National Infrastructure Planning  
Temple Quay House  
2 The Square  
Bristol, BS1 6PN

Our Ref: EN010127

### **Application by Mallard Pass Solar Farm Limited for an Order Granting Development Consent for the Mallard Pass Solar Project**

#### **Advice following issue of decision to accept the application for examination**

No dimensions are to be scaled from this drawing.
All dimensions are to be checked on site.
Area measurements for indicative purposes only.
© LDA Design Consulting Ltd. Quality Assured to BS EN ISO 9001: 2015
Source: Ordnance Survey

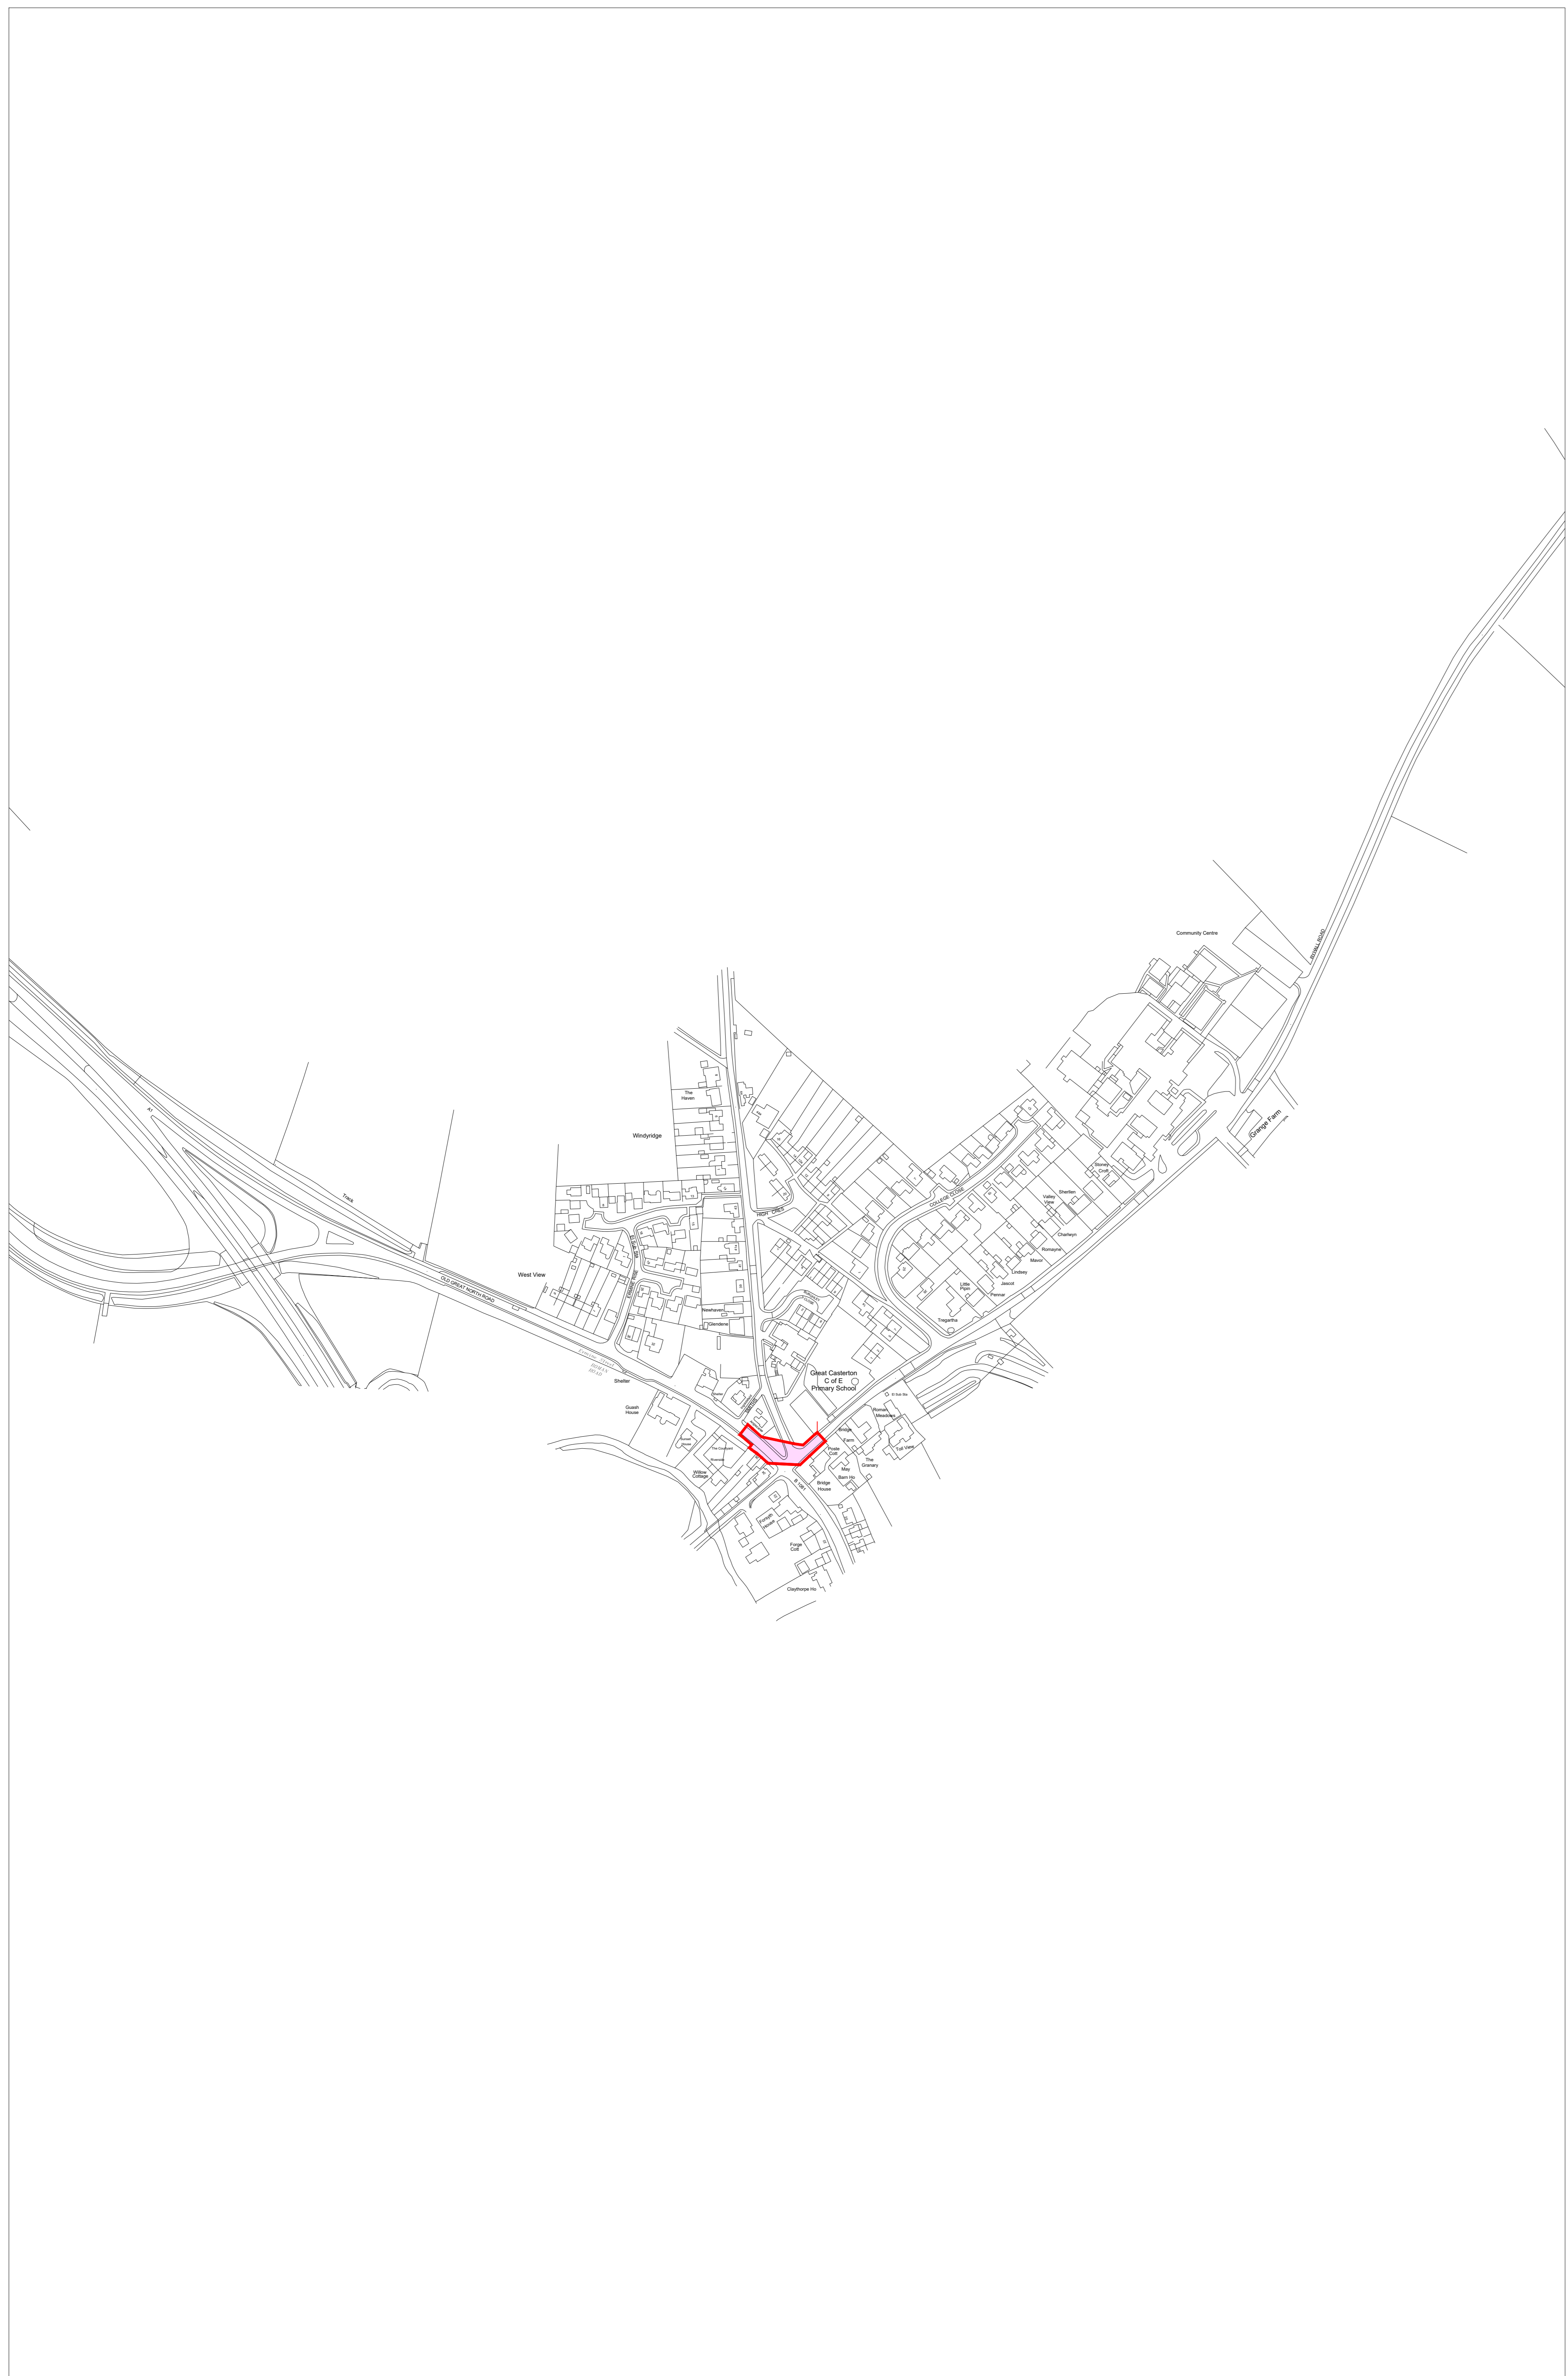
Sheets 1 and 3 are missing areas which, albeit outside of the Order limits, are close enough to the Order limits to warrant inclusion.
